From: IMoffatSmith@aol.com
Sent: 29 September 2008 12:23
To: planning
Subject: 3/2008/0749 Withgill Farm

Bashall Eaves and Mitton Parish Council have the following comments:

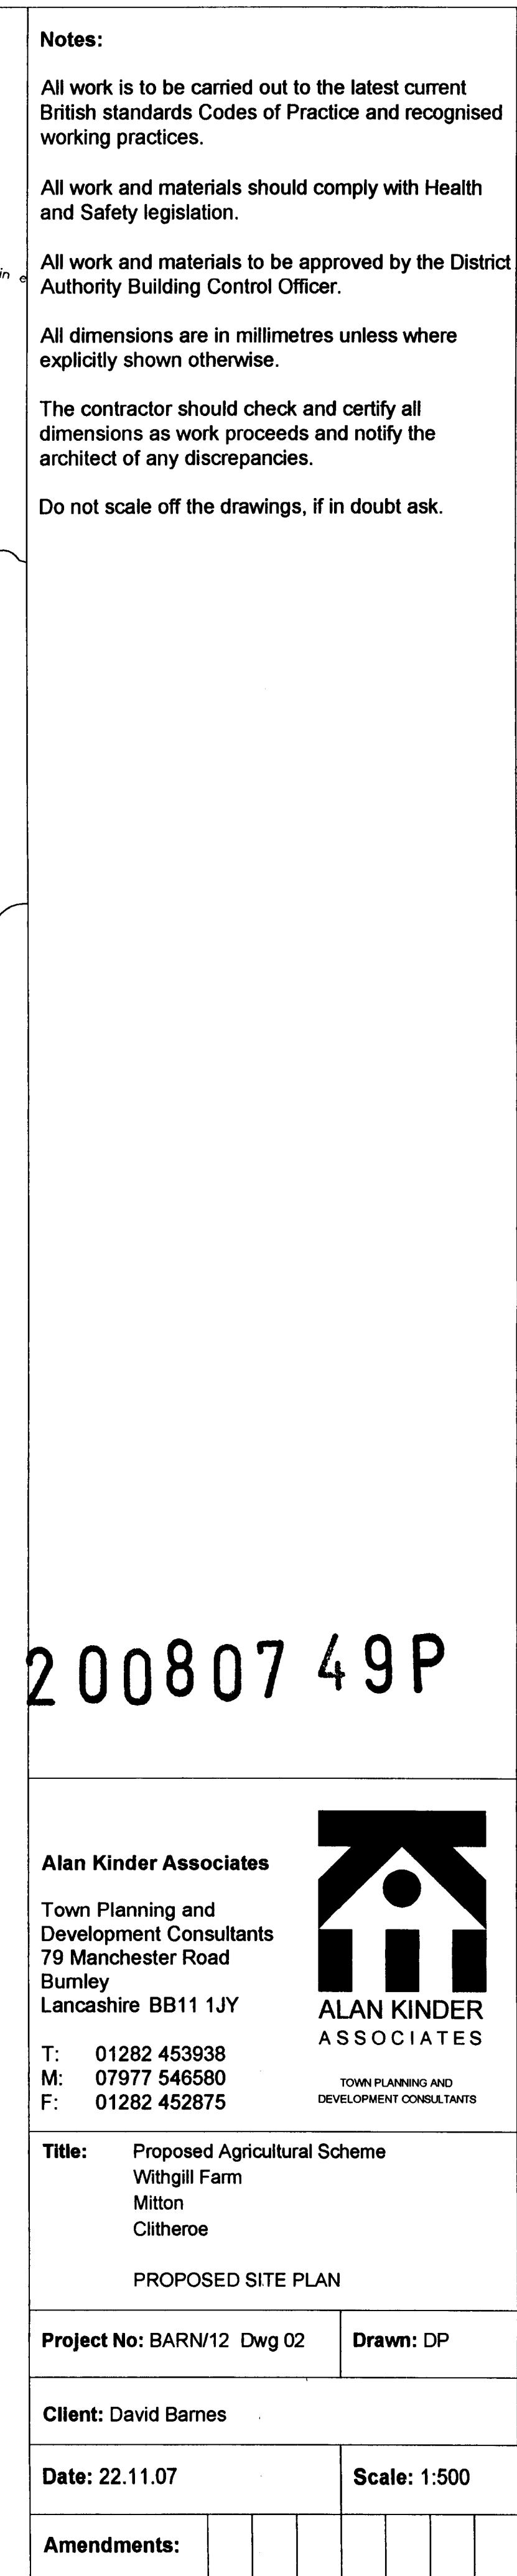
While essentially replacing existing structures this development will be larger than that existing at present. It would seem appropriate to extend Planting Area D to screen it.
